CITY OF ALBUQUERQUE

**RE: Lot 15 Block 2, Volcano Cliffs Unit 19, SAD 228
6508 Camino Del Oeste NW
Grading and Drainage Plan
Engineers Stamp Date 11/28/17 (D10D003G15)**

Based upon the information provided in your submittal received 11/29/17, this plan is approved for Grading Permit.

ENGINEER'S SEAL	6508 CAMINO DEL OESTE	DRAWN BY WCMJ
	GRADING AND DRAINAGE PLAN	DATE 11-23-17
		21811-LAYOUT-10-16-17
11/28/17 11/26/17		SHEET # —
DAVID SOULE P.E. #14522	Rio Grande Engineering 1606 CENTRAL AVENUE SE ALBUQUERQUE, NM 87106 (505) 872-0989	JOB # 21808

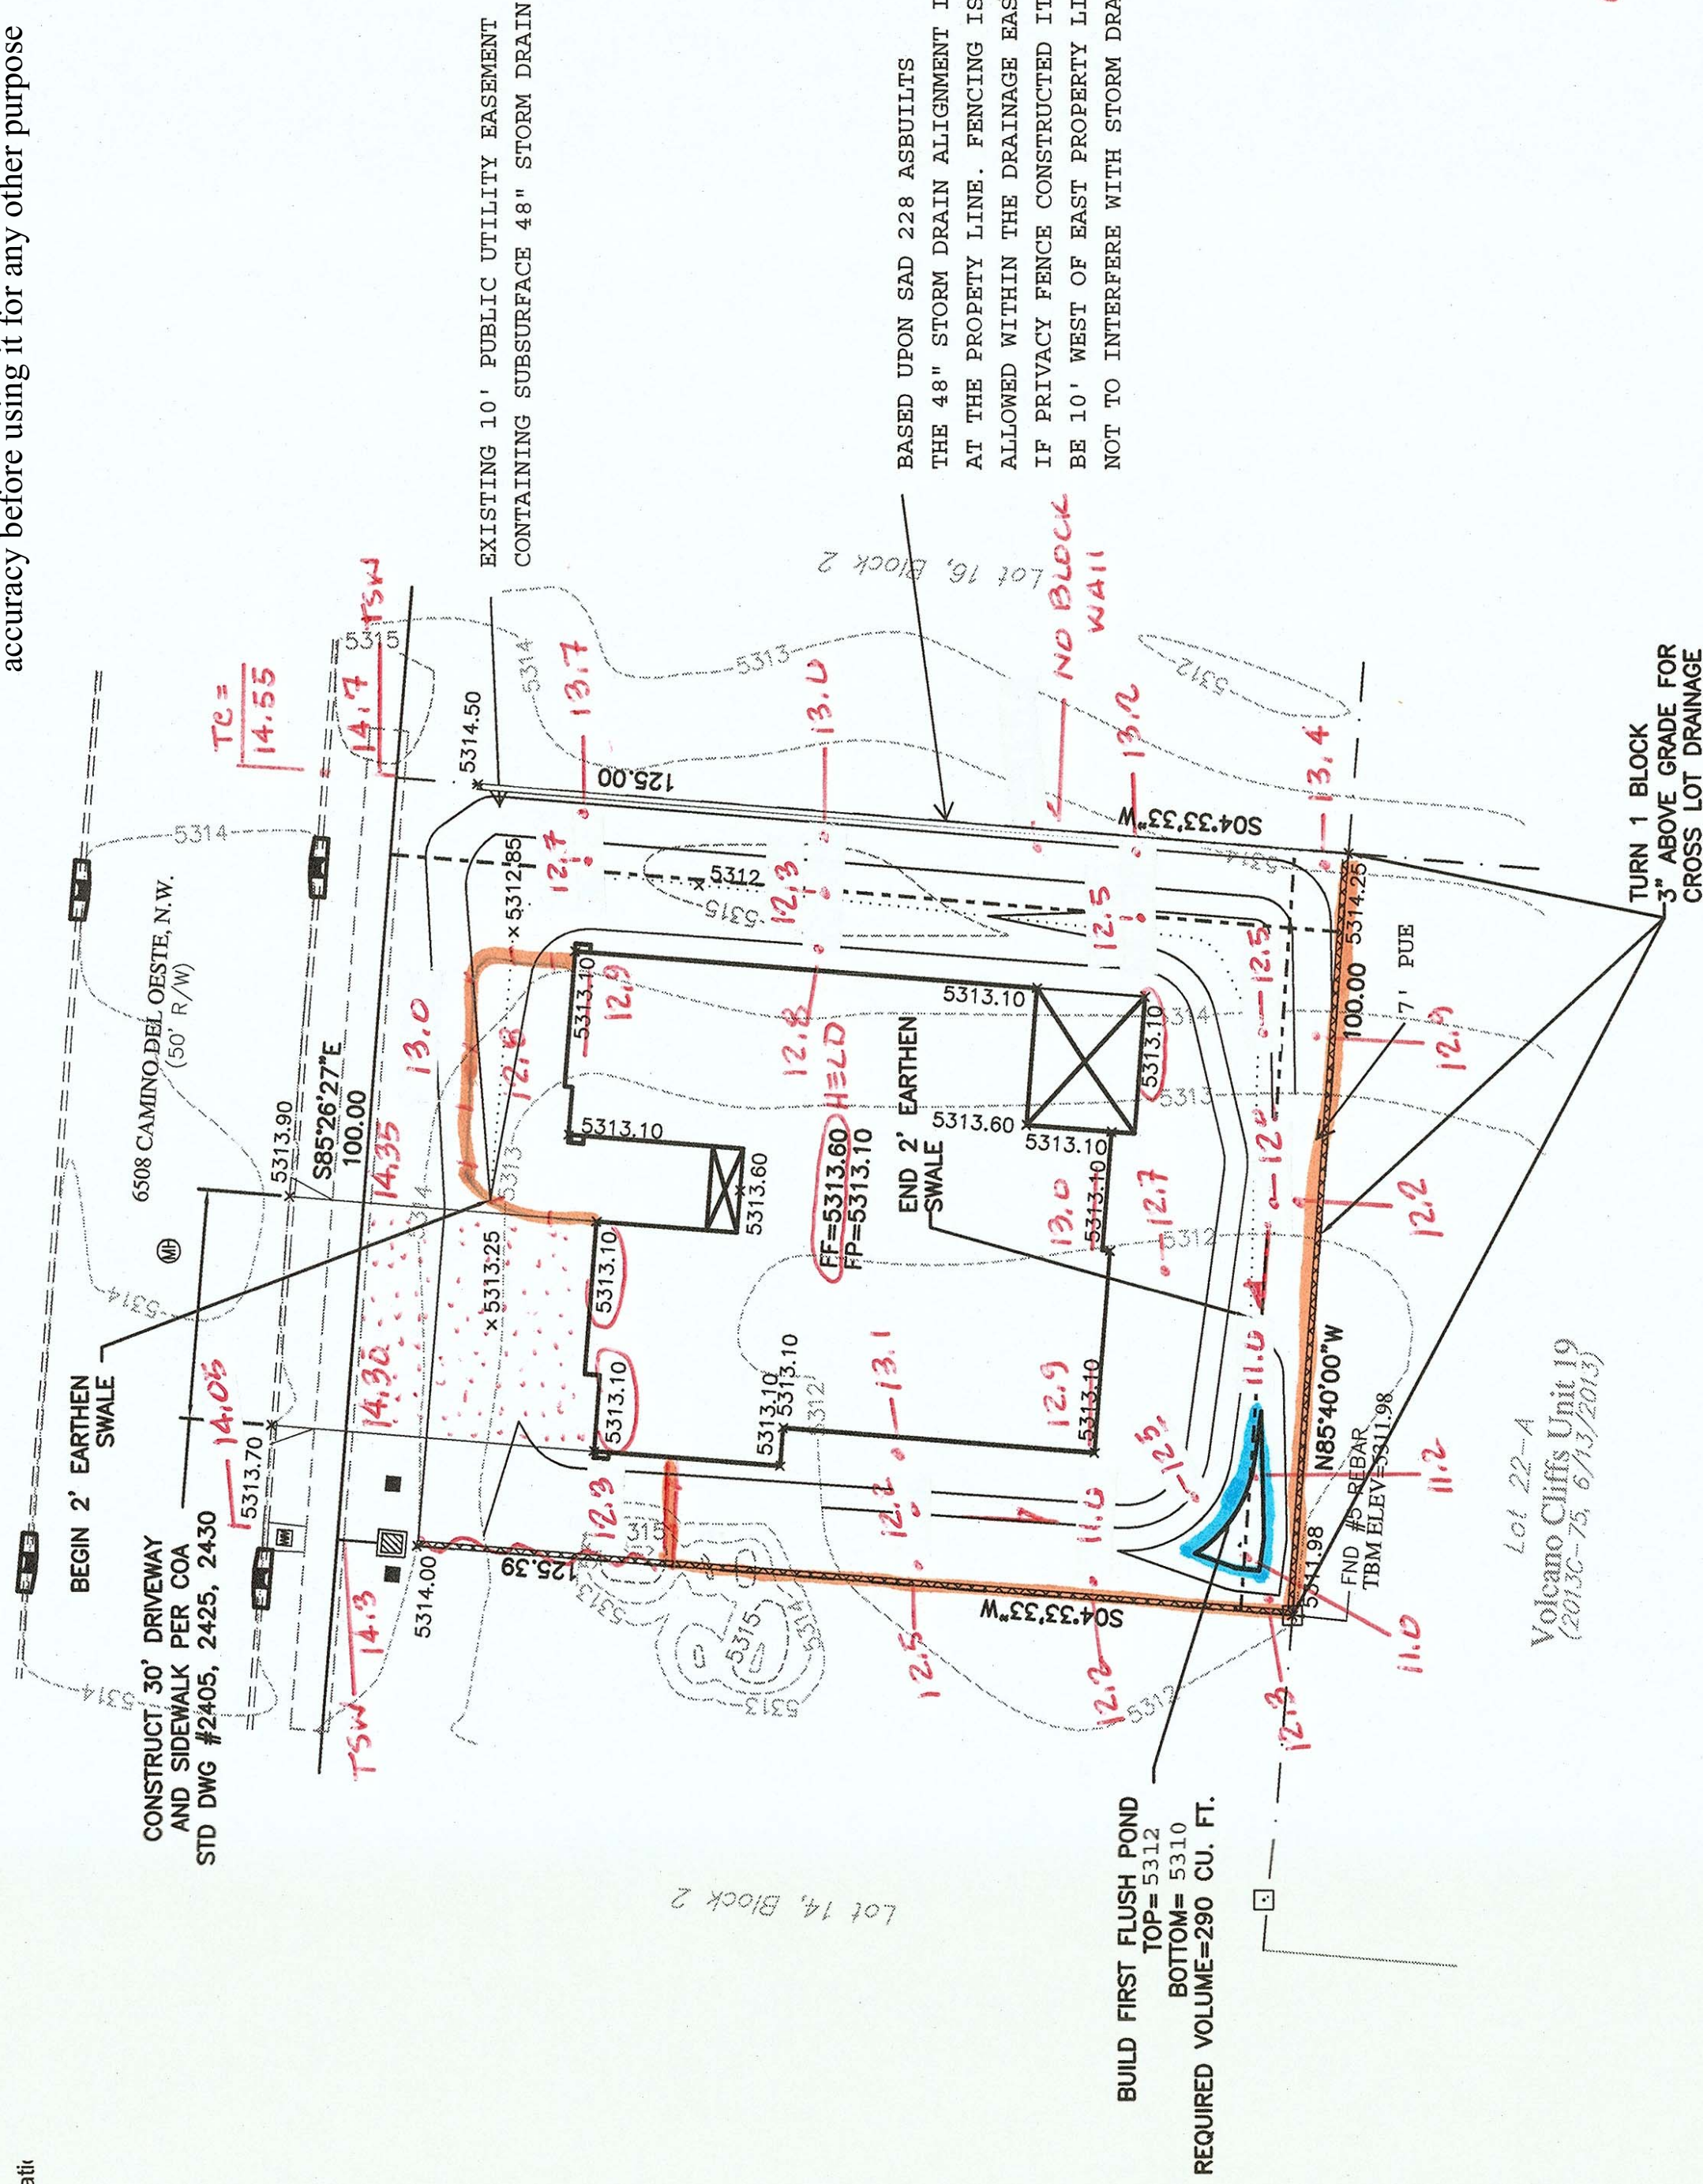
Reiterate to the Owner/Contractor that a separate permit for a garden/retaining wall must be obtained and the east garden wall will need to be 10 feet inside the property line, with an approved G&D plan and Pad Certification.
